CITY OF ALBUQUERQUE

July 3, 2019

Re: Country Club Plaza Ph 3, 1716 Central Ave SW
Request for Conditional Certificate of Occupancy - approved
Certification dated: 7-2-19

PROJECT Country Club Plaza | Building 3
1716 Central Avenue SW
Albuquerque, NM 87104
TITLE CONCEPTUAL GRADING & DRAINAGE PLAN

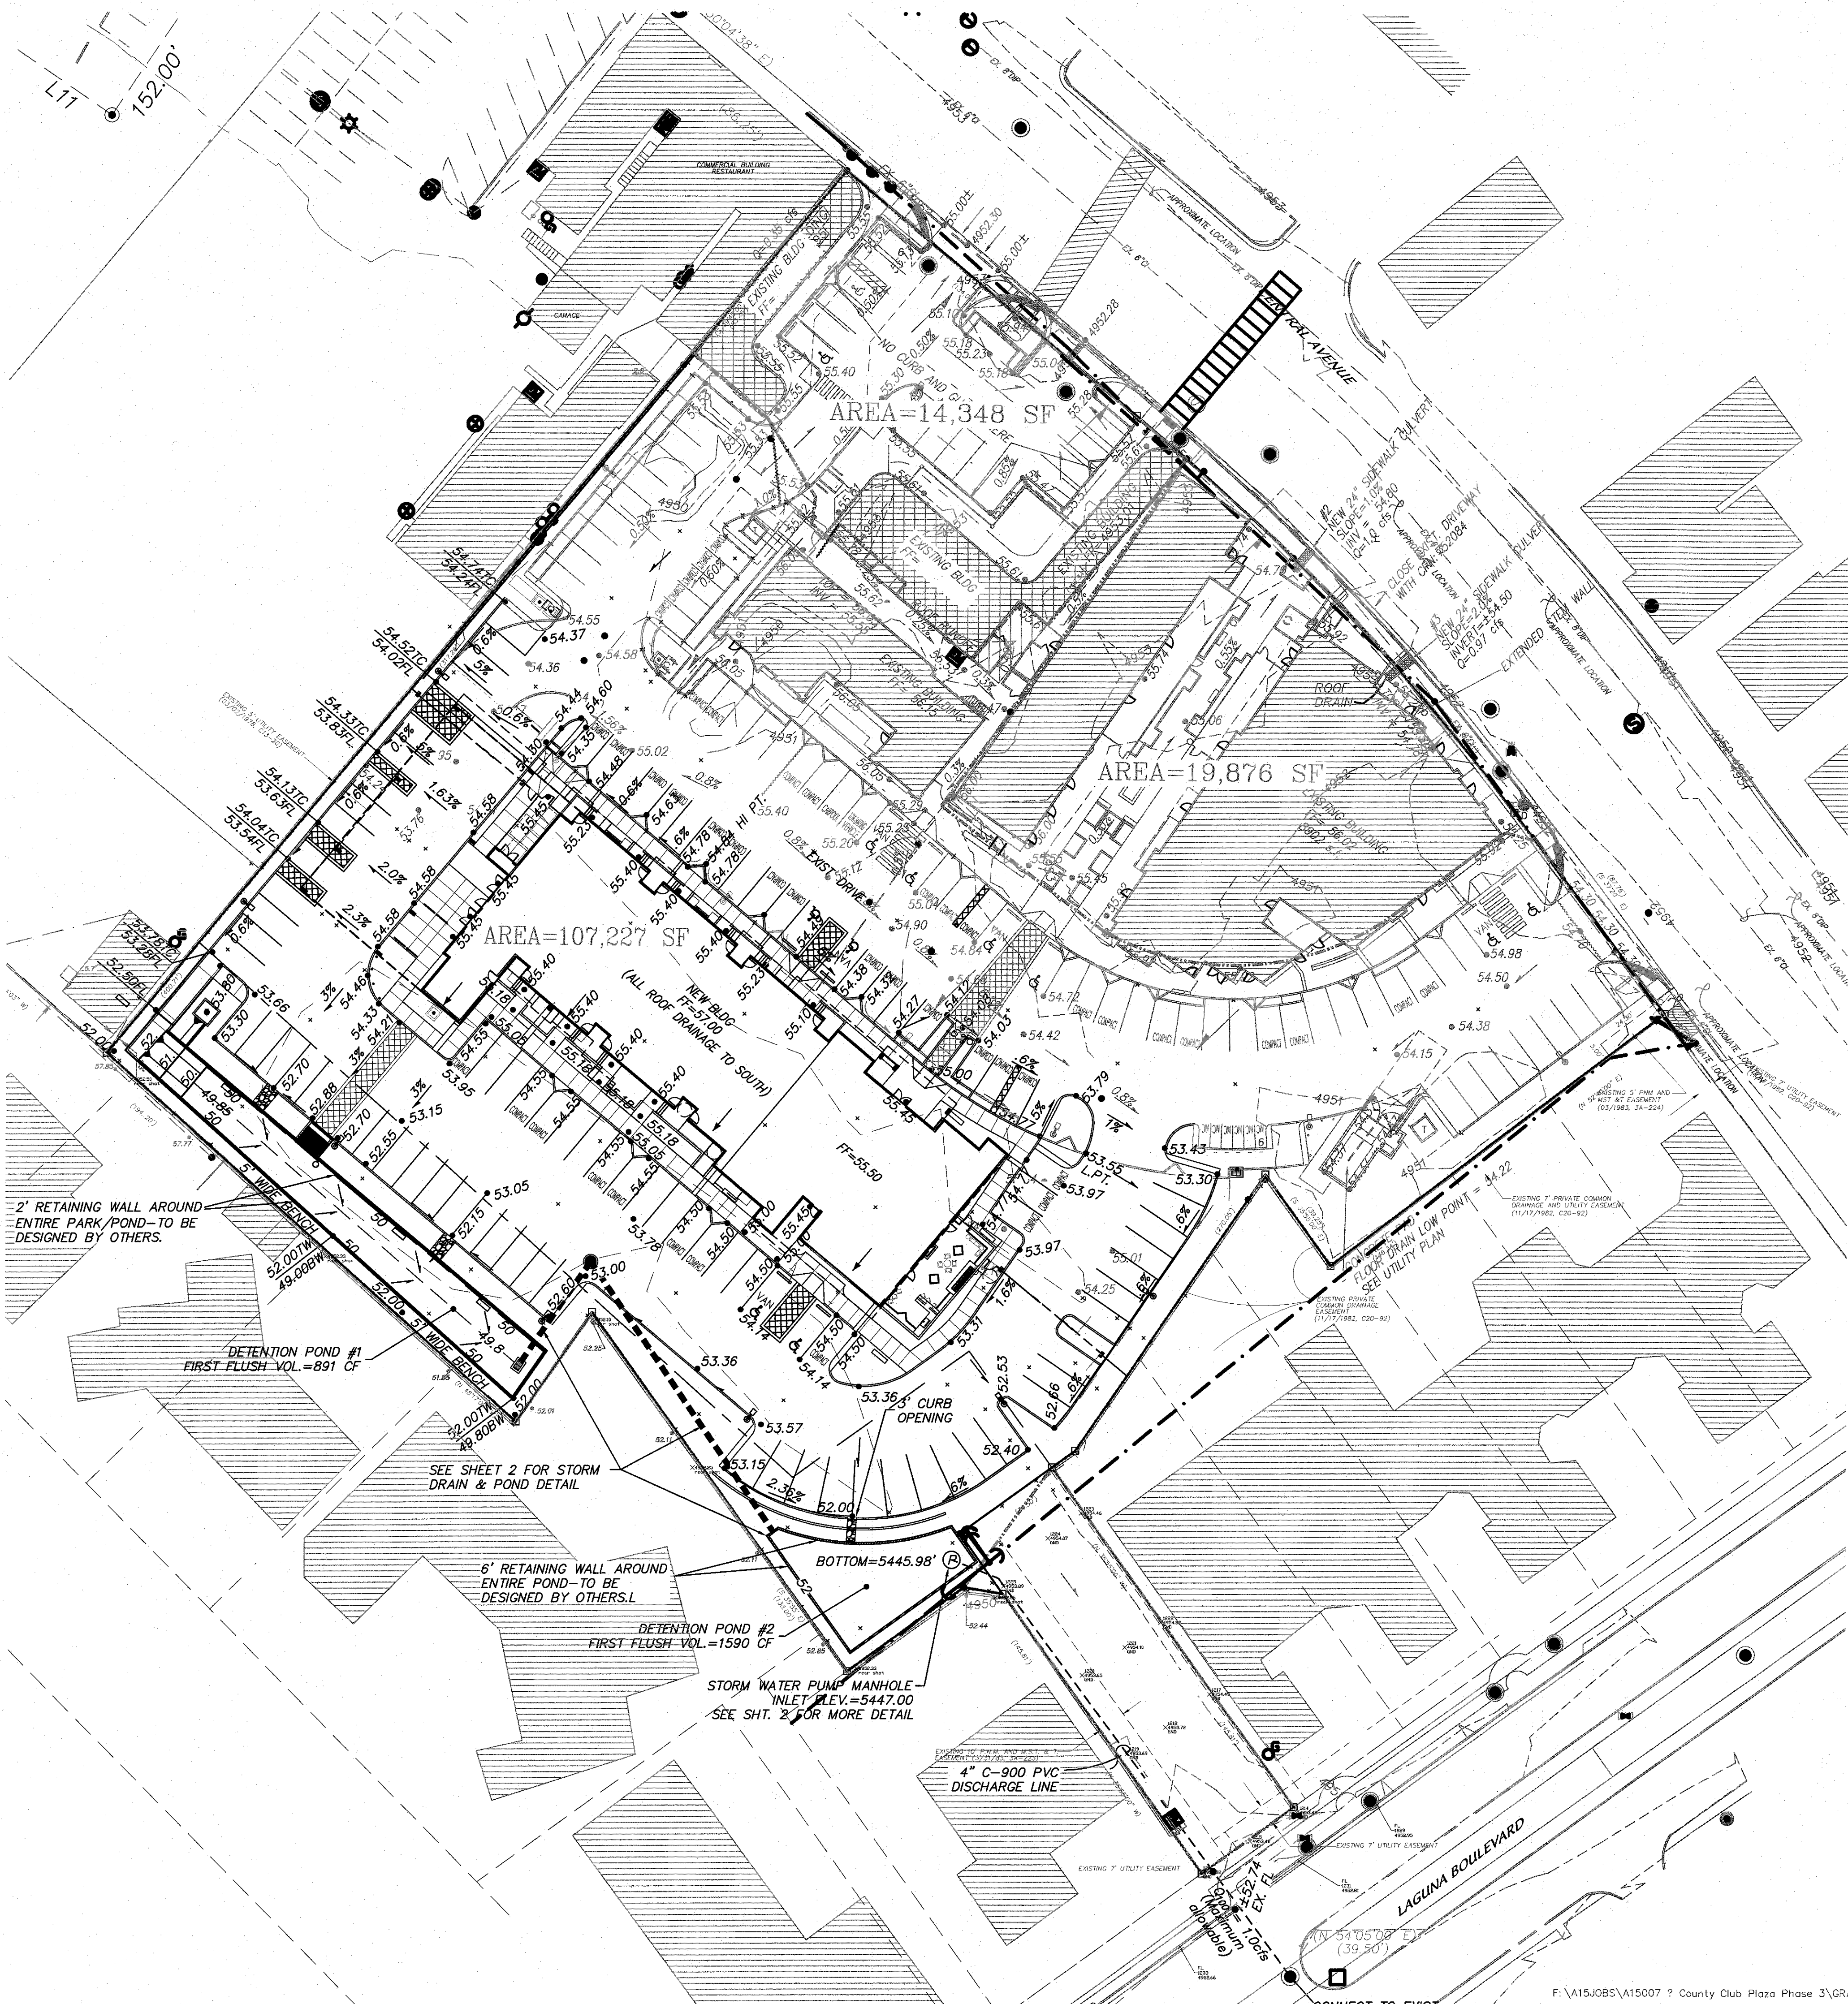
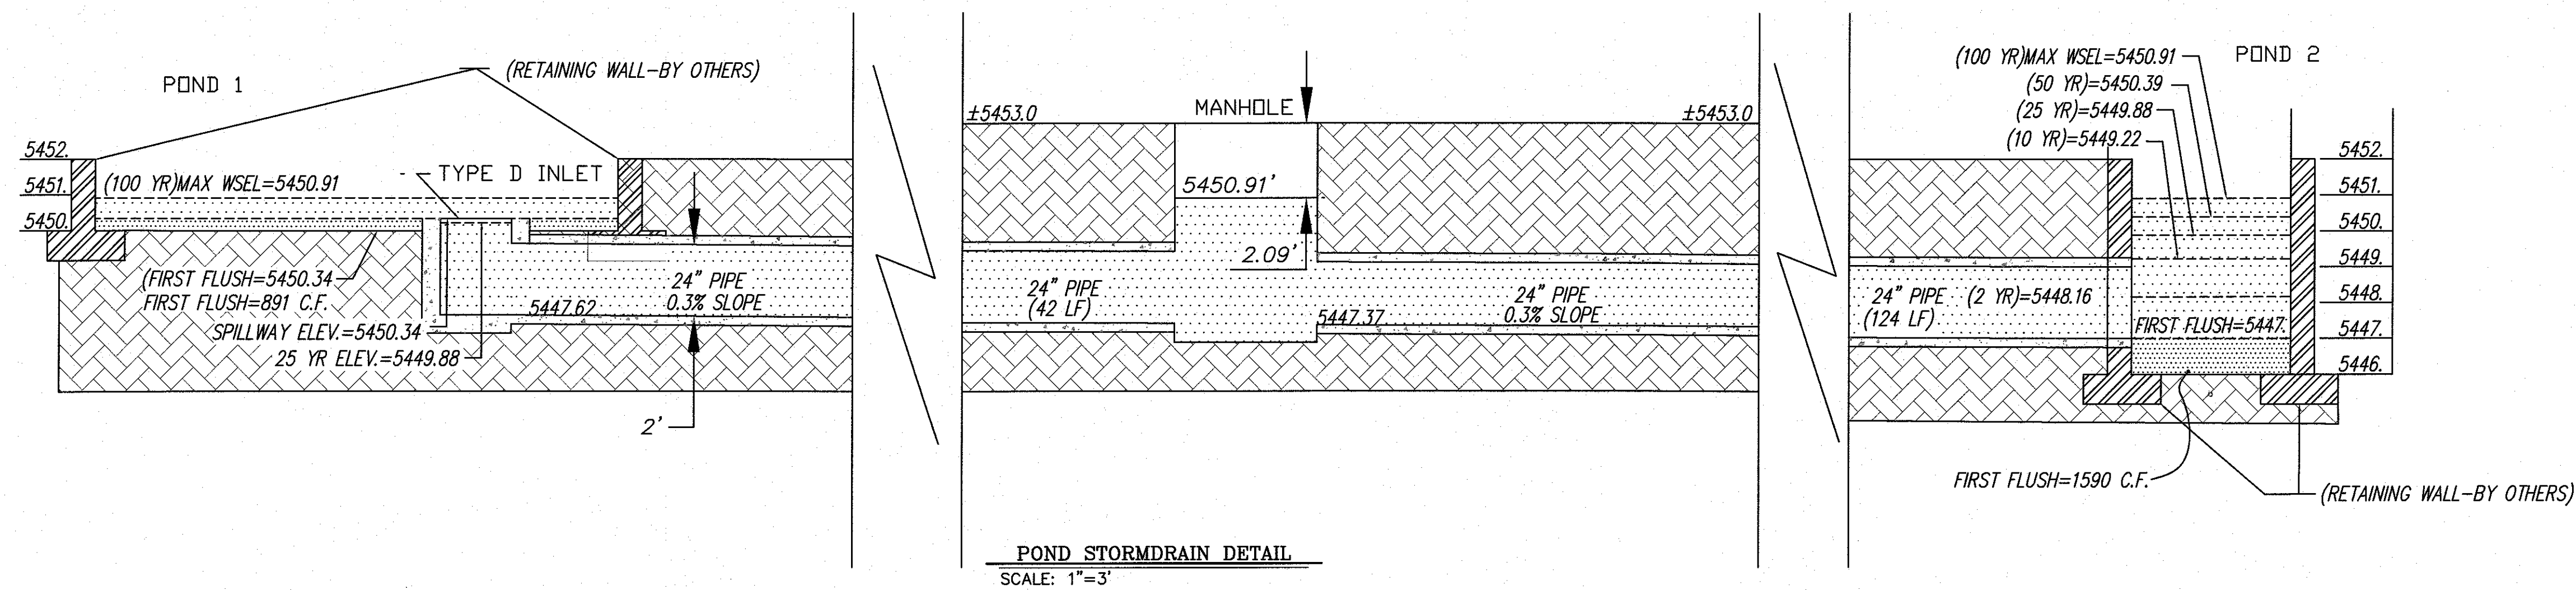
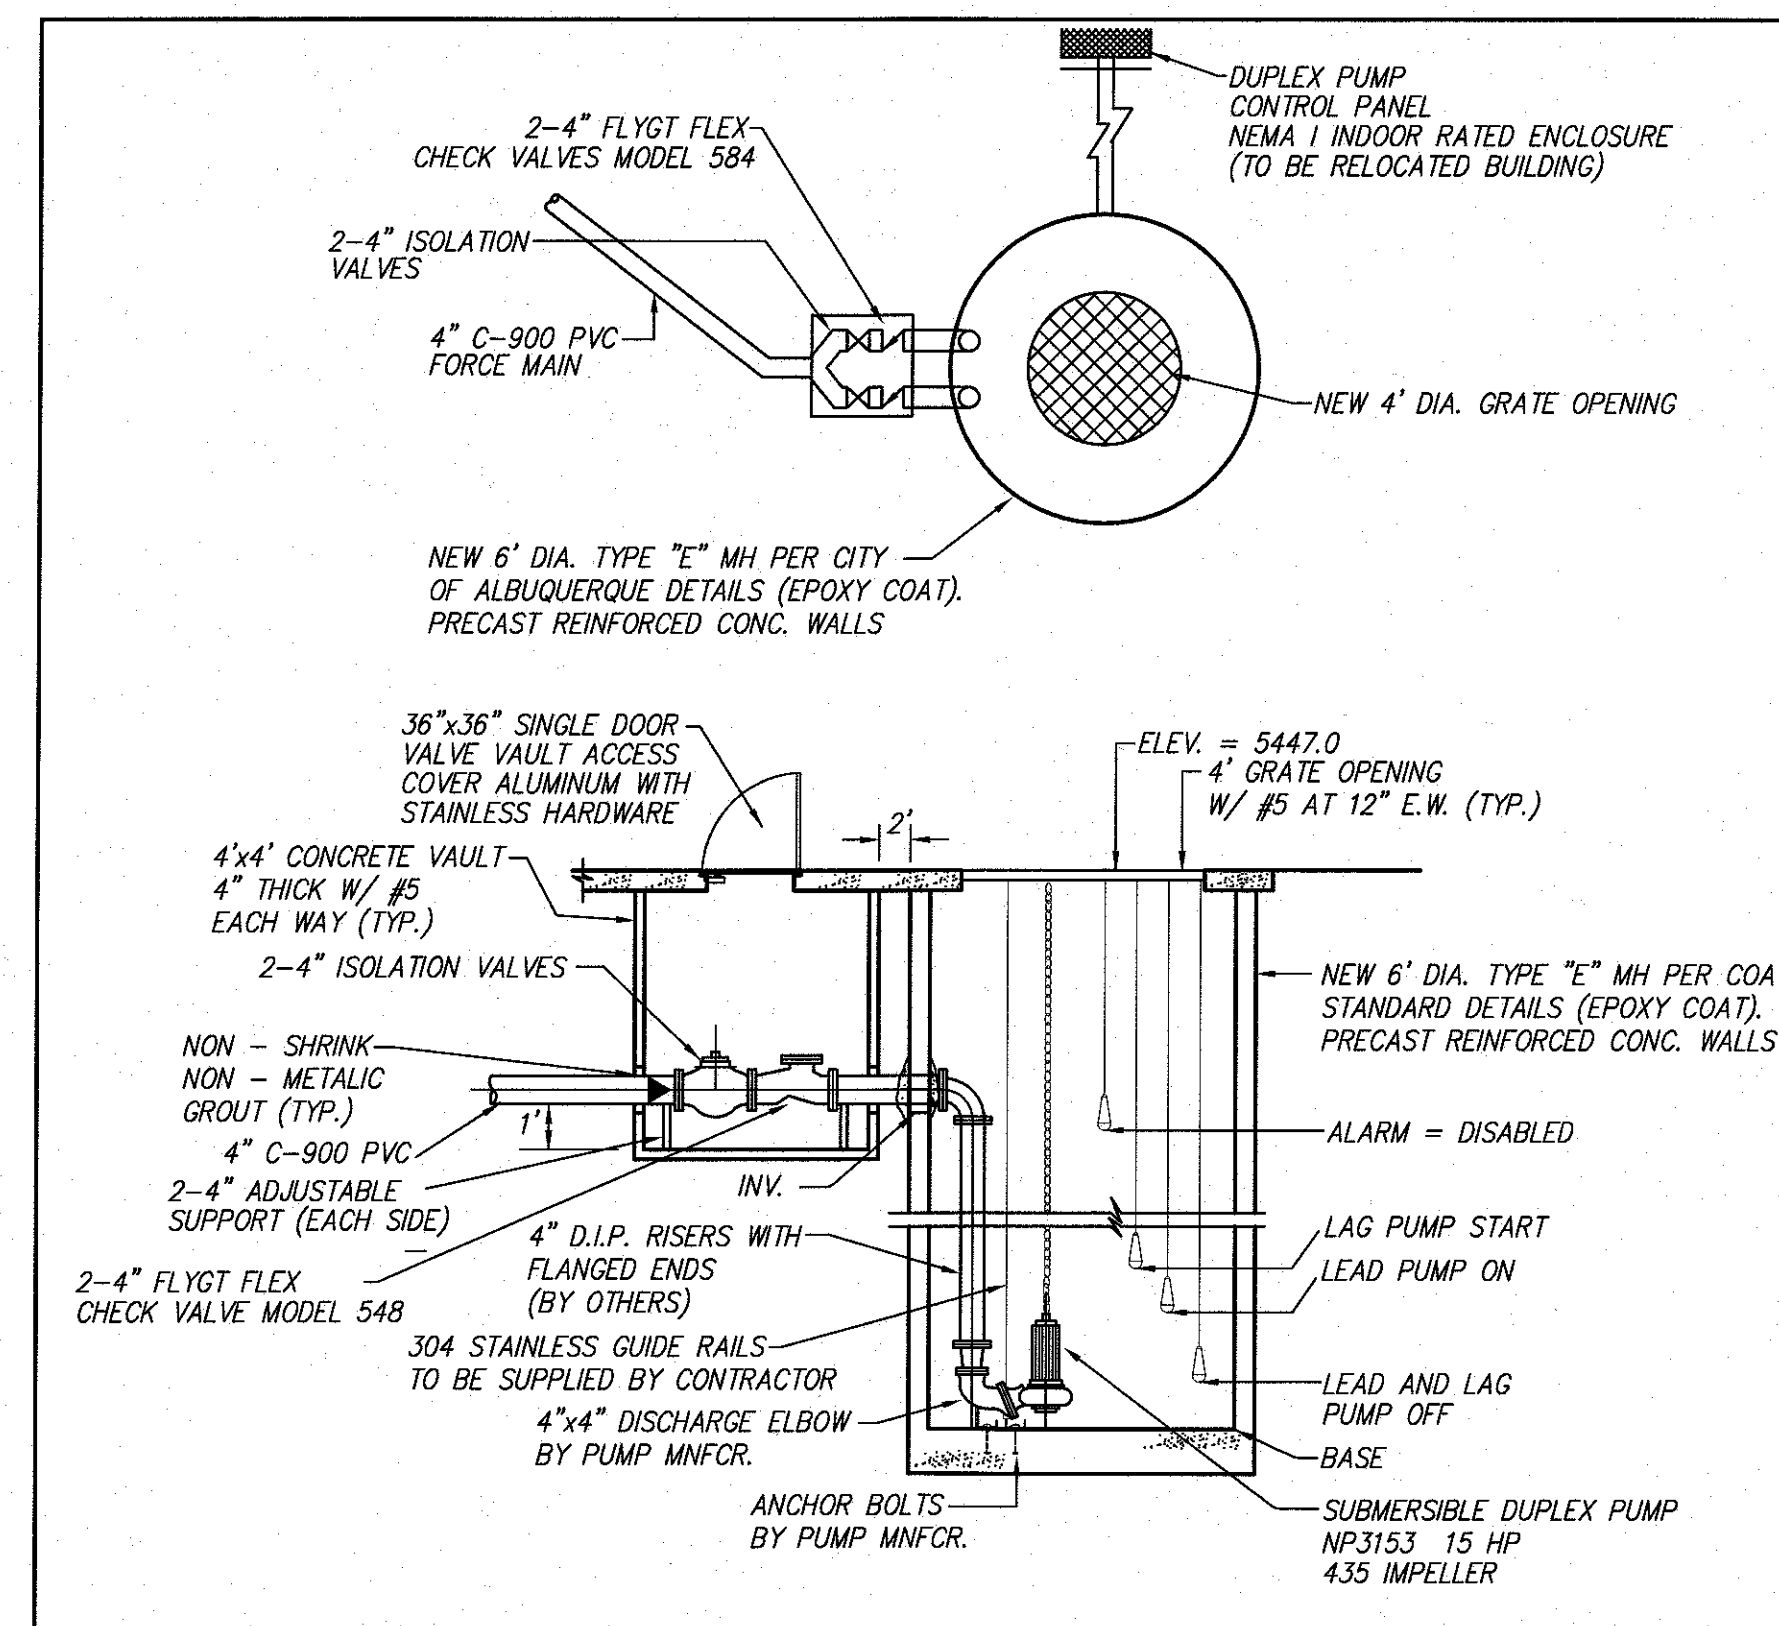
1. The sidewalk culverts are a complete remove and replace. Construct per City Detail 2236; the drain line should also be constructed similar to City Detail 2235 (see attached). Once complete, contact Rita Harmon for re-inspection or any questions (328-3221, rharmon@cabq.gov)
2. Raise pump control panel above top of retaining wall in Pond 2.
3. Excavate 1-2 courses of CMU and apply asphalt emulsion damp-proofing to elevation 53' around detention Pond 1
